EF13/5058, DOC17/474816-02
SSD 8344

SSD 8344 – KELLYVILLE NORTH PUBLIC SCHOOL - EIS

SSD 8344 KELLYVILLE NORTH PUBLIC SCHOOL EIS

Noise level charts Tuesday 30 May 2017

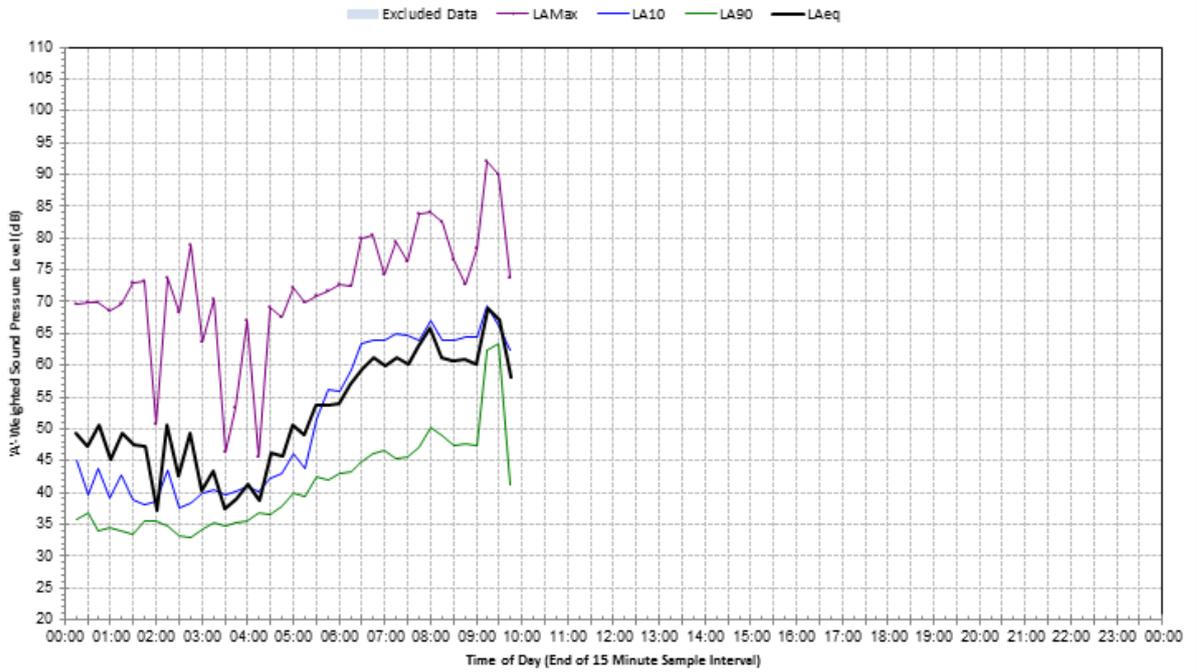
The proponent has not obtained a 'week's worth' of valid data from which to derive daytime background noise levels. In particular, the logger data graphs in Appendix A to the Acoustic Report for Tuesday 23 May and Tuesday 30 May 2017 show that –

- only a small amount of data was collected for these daytime periods, and
- that data appears to be adversely affected by setup and retrieval noise.

The EPA notes that the Assessment Background Levels (ABLs) for both Tuesdays is markedly higher than for other days and should be excluded from the Rating Background Level (RBL) calculation. And thus, results in an RBL of 36 dBA, which should apply to both daytime and evening assessment periods.

- (a) re-measure background noise levels, and measure representative noise levels for the area in accordance with the guidance material in the Industrial Noise Policy, or
- (b) adopt a background noise level of 36 dB(A) and a Project Specific Noise level (PSNL) of 41 dB(A) for the day time and evening assessment periods.
